**Project: The Ribbon Hotel, Serviced Apartments and Retail, Darling Harbour, Sydney.**

In response to our recent Development Application Submission please find below an itemized table listing the issues raised with a corresponding commentary and document reference if applicable. This table responds to (in order):

2 HOTEL/SERVICED APARTMENTS L06
1:200

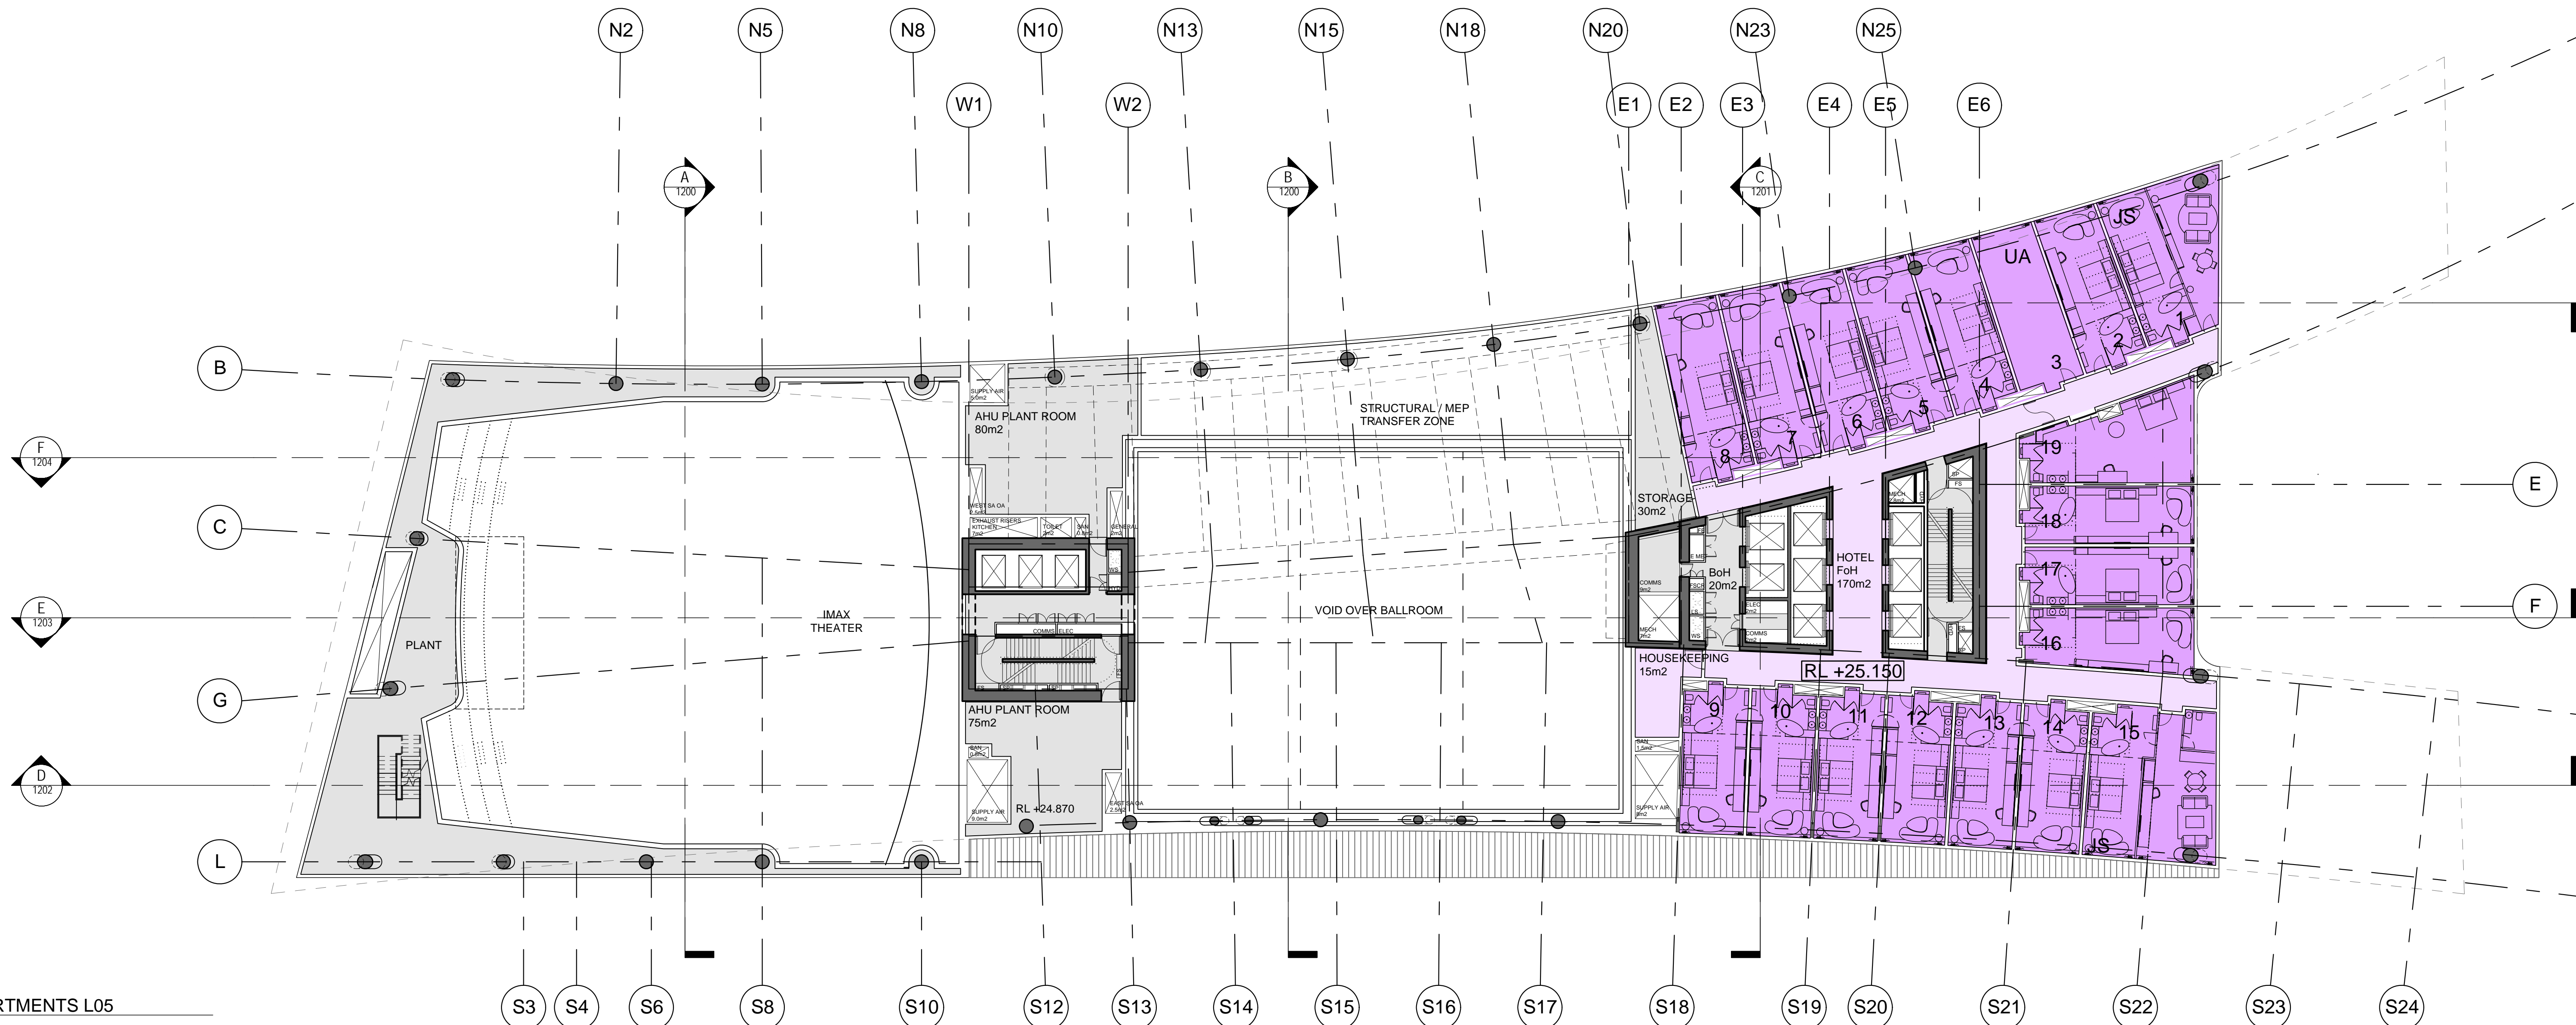
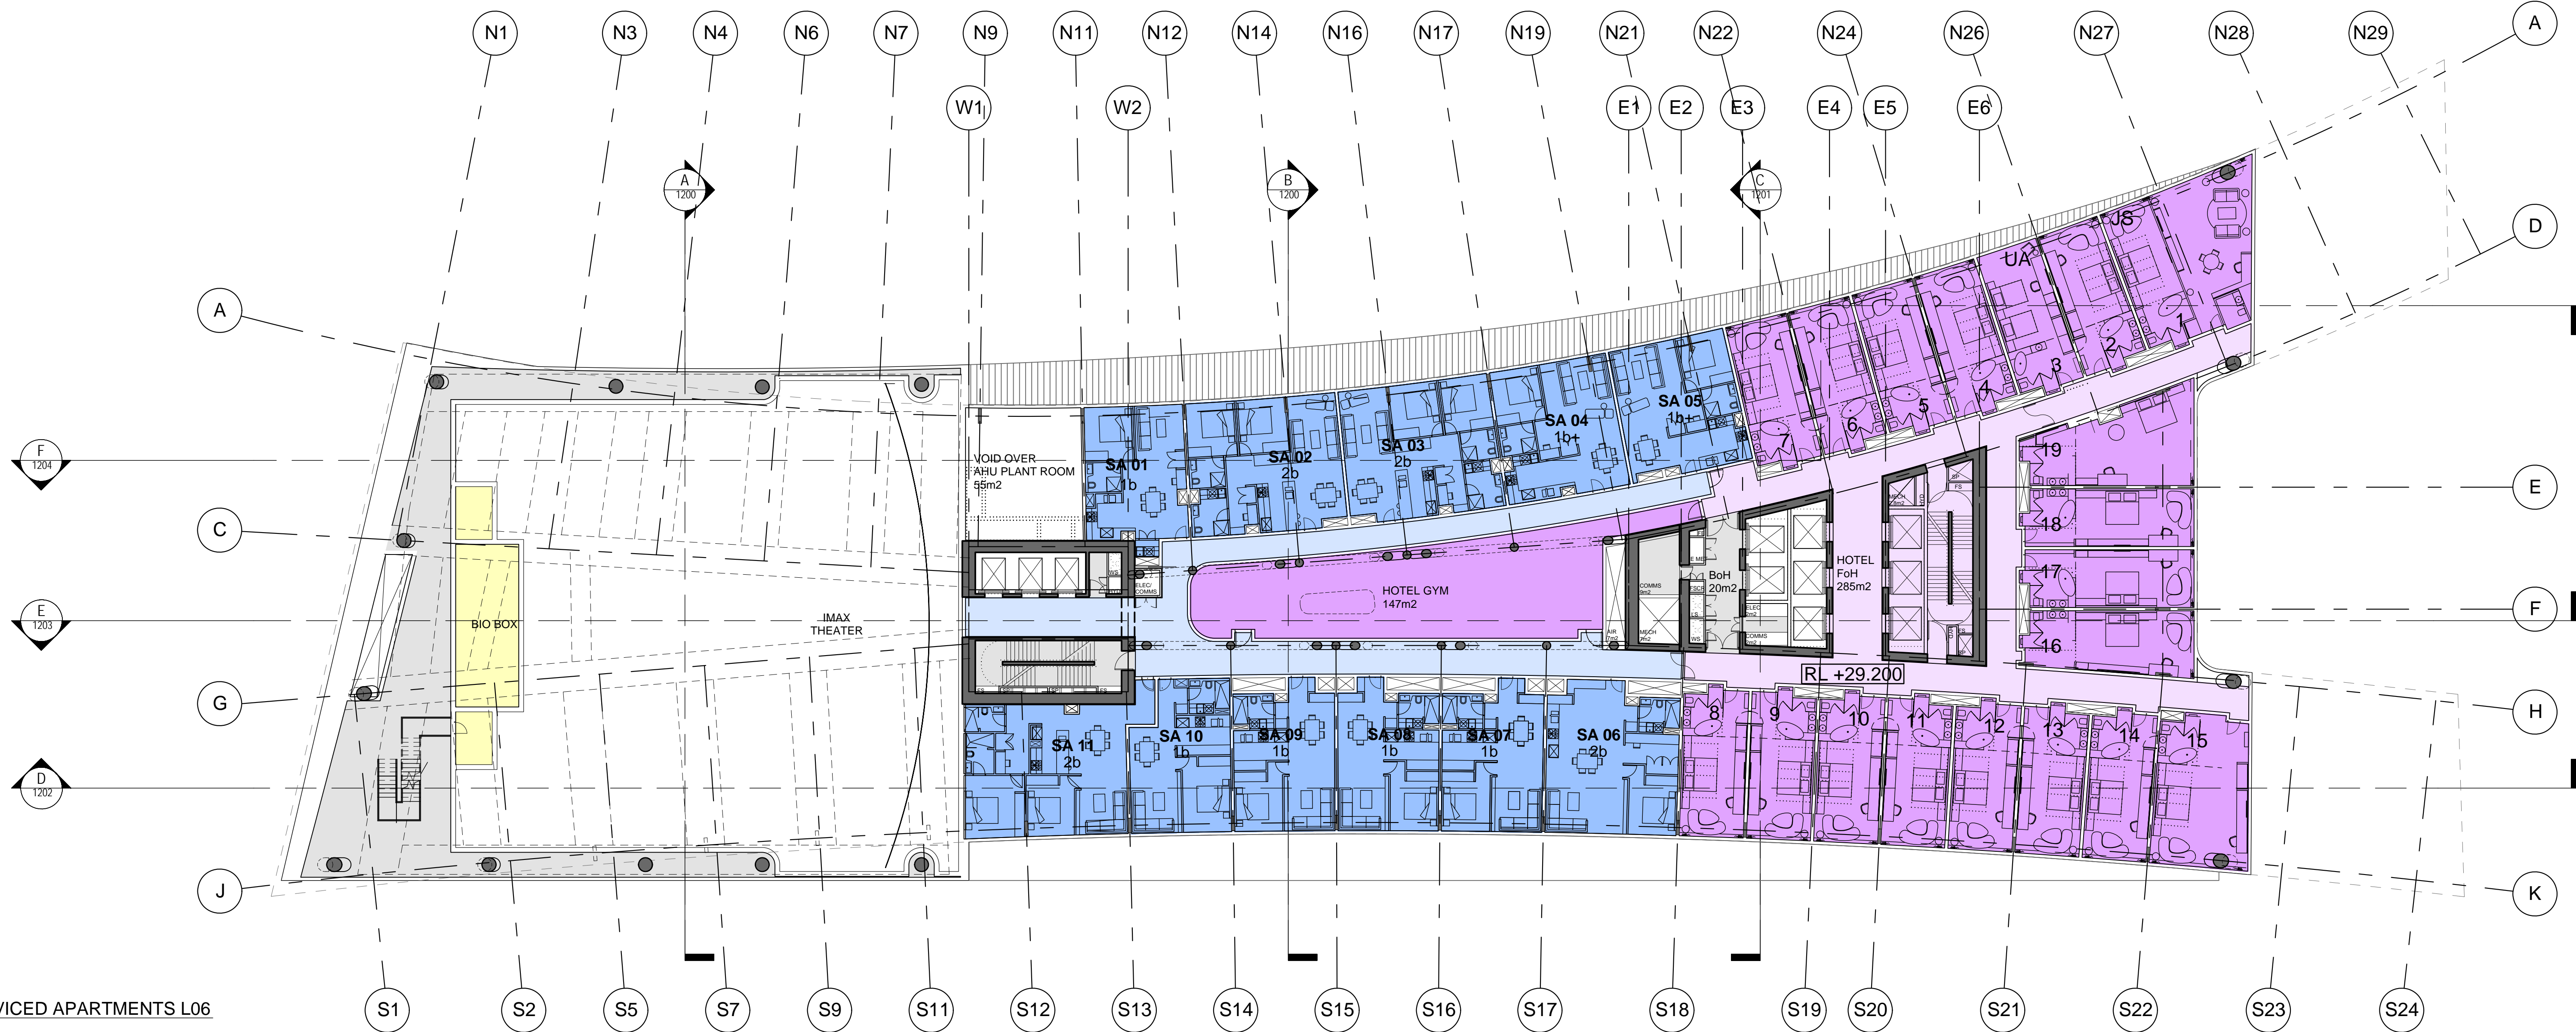
51	The level 6 plans show corridors as narrow as 1m in order to accommodate the hotel gym entry. This corridor should be increased to a minimum of 1.4m.	Noted, this was a drawing omission.	Please refer to HASELL's GA Plans –Hotel and Serviced Apartments L05 and L06 ARCH-HSL-DD-1105 rev E.
52	Some hotel and serviced apartment suites do not indicate the entry doors.	We have checked our drawings and all units show entrance doors, please note that multi bay suites and serviced apartments only show one entrance door.	No updates proposed
<b>NSW Government Planning &amp; Environment</b>			
<b>Serviced Apartments and Hotel Use</b>			
2	A schedule is required setting out the number of serviced apartments and hotel rooms including typology, size and whether they are accessible/adaptable.		Please refer to HASELL's Hotel and Serviced Apartments Schedule of Accommodation ARCH-HSL-DD-SK-005.1 & 2

SALE @ B1	DRAWN RT	CO-ORD JO	REVIEWED JO	APPROVED CW
PROJECT NUMBER 004409	DRAWING NUMBER ARC-HSL-DD-1950			REV D

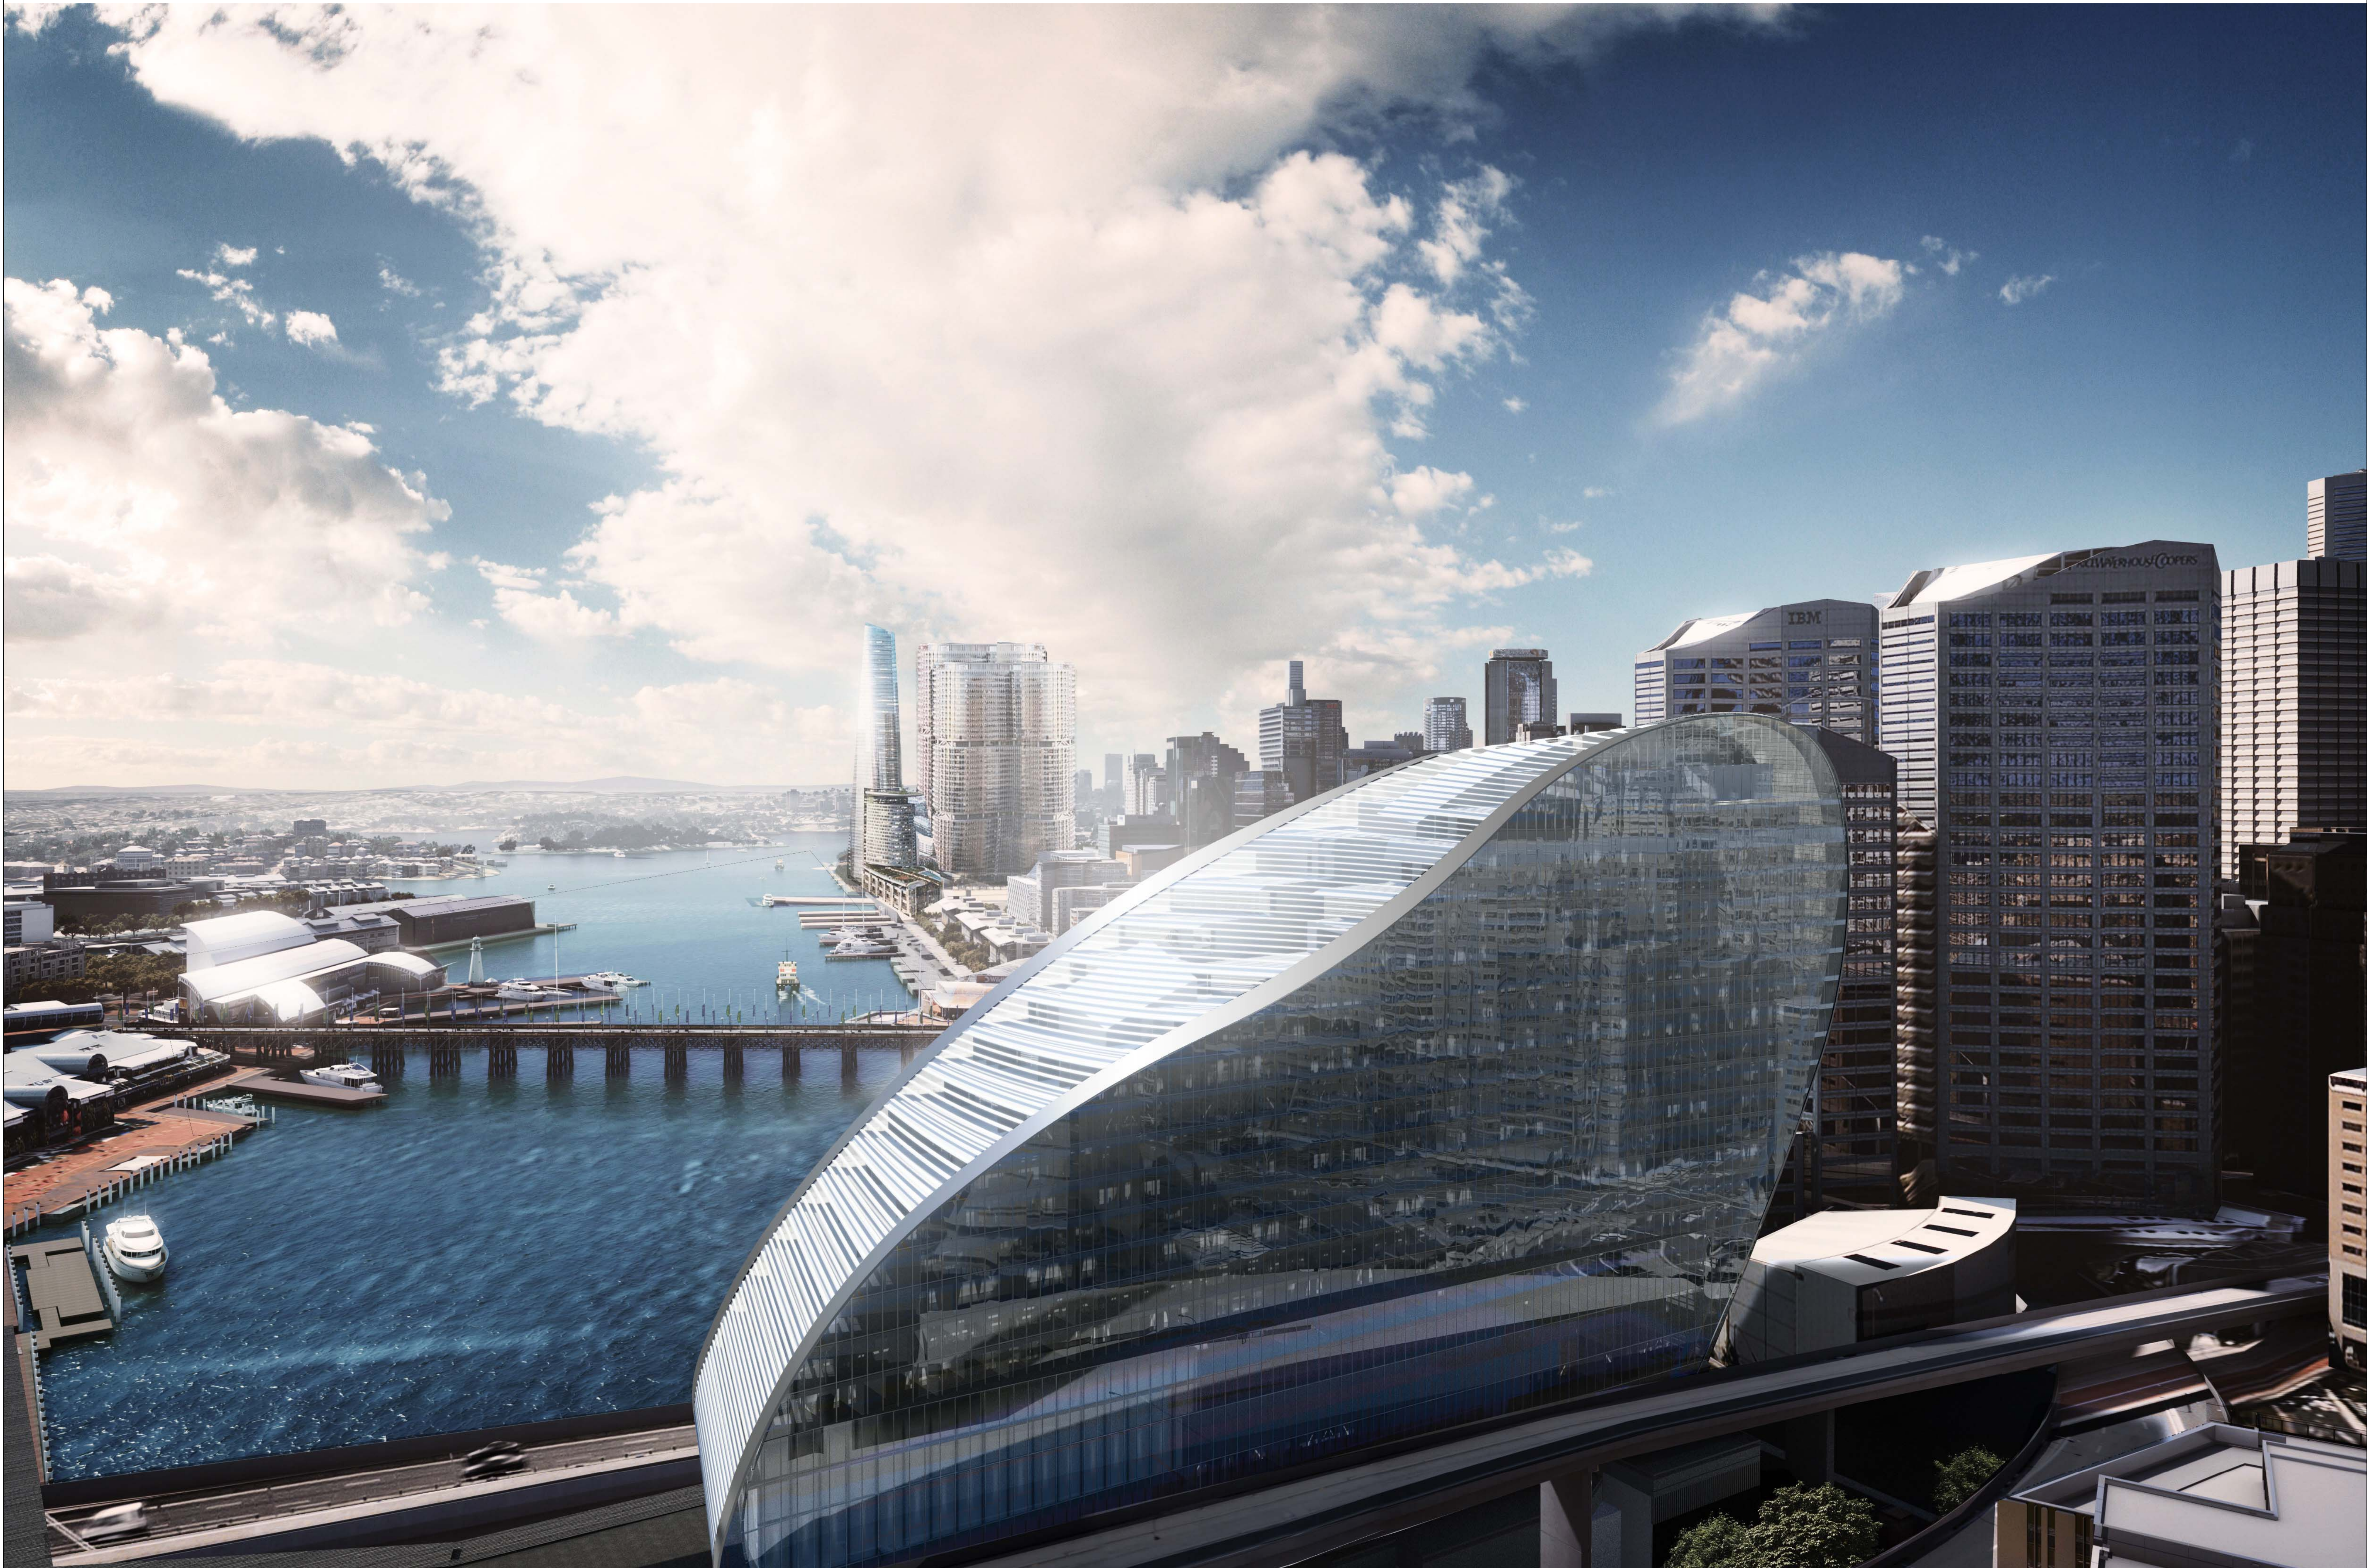
Item	Identified Issue (verbatim quote)	HASELL Comments	HASELL Document
<b>NSW Government Planning &amp; Environment (cont.)</b>			
	assessing the appropriateness of the operable roof panels including recommendations for conditions for when the roof panels can be opened.		
4	Revised elevations and photomontages should be provided clearly identifying the different materials and finishes recommended in supporting report including cladding and/or double glazing, shading elements to mitigate glare impacts, and wind screens.	CUNDALL's Reflectivity Study dated 16/12/2015 Rev B. items 3.6.1 and 4 states the required Maximum Visible Light Reflectivity values for all building envelope components; all specified materials meet the Reflectivity Study requirements.	Please refer to HASELL's Materials Palette ARCH-HSL-DD- 1930 rev D and Artists Impression 1 to 3 ARCH-HSL-DD-1950, 1951 & 1952 all revision D
<b>Parking and Traffic</b>
